Application: 3/2020/0383

Application Site: Brockthorn Barn Wigglesworth Road, Slaidburn

Proposal: Barn conversion to 1 dwelling

1:500 OS Plan / Site Plan

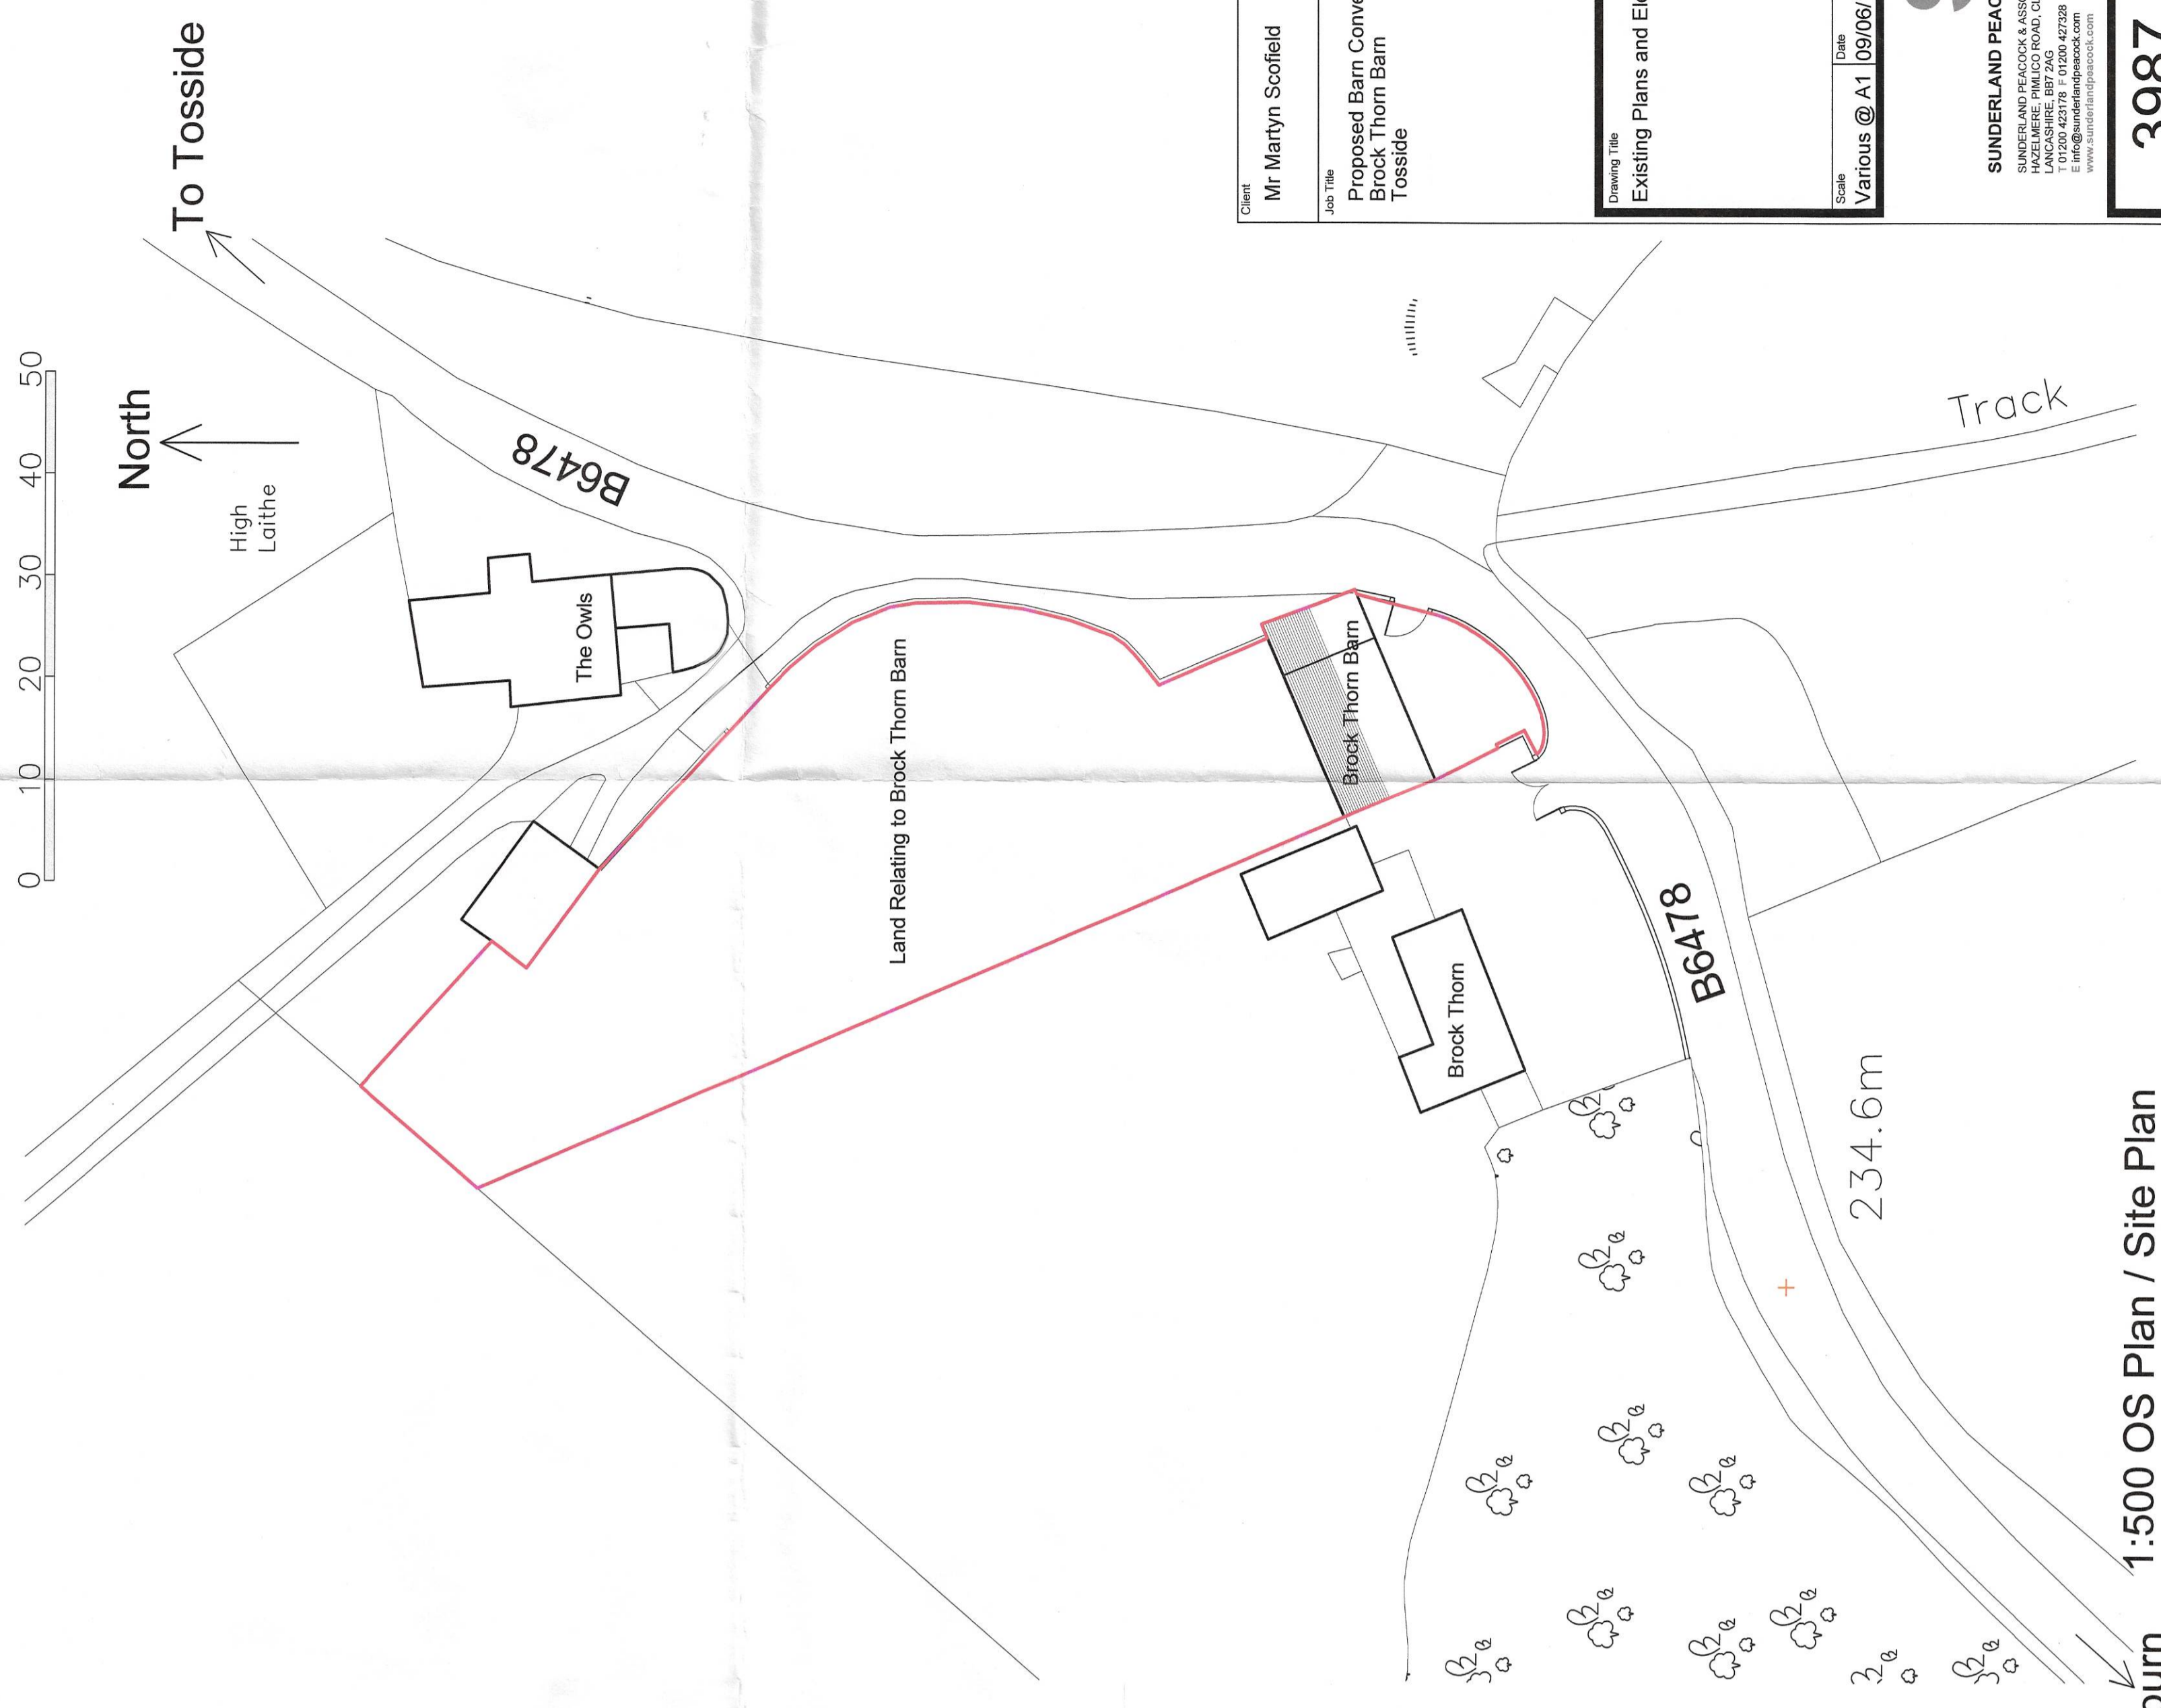
The proposal raises no highway concerns and I would therefore be minded to raise no objection to this application however there are a couple of issues that need further clarification. Although no gates are proposed for the new access if gates are or were to be erected at a later date these should be erected south of the tarmacked entrance area to ensure that waiting vehicles do not obstruct access to "The Owls". Secondly the existing field access to the front of the property shall require permanently stopping up to prevent its future use as a vehicle access point. Should your council be minded to approve this application I would request that the following condition be placed on any permission that may be granted

- 1 There shall be no direct vehicular access between the site and Wigglesworth Road and to that end a continuous wall or fence shall be erected before development commences and be permanently maintained on the highway boundary, all vehicular access being obtained from the proposed access point adjacent to The Owls. Reason: To limit the number of access points to the highway network as an aid to road safety.
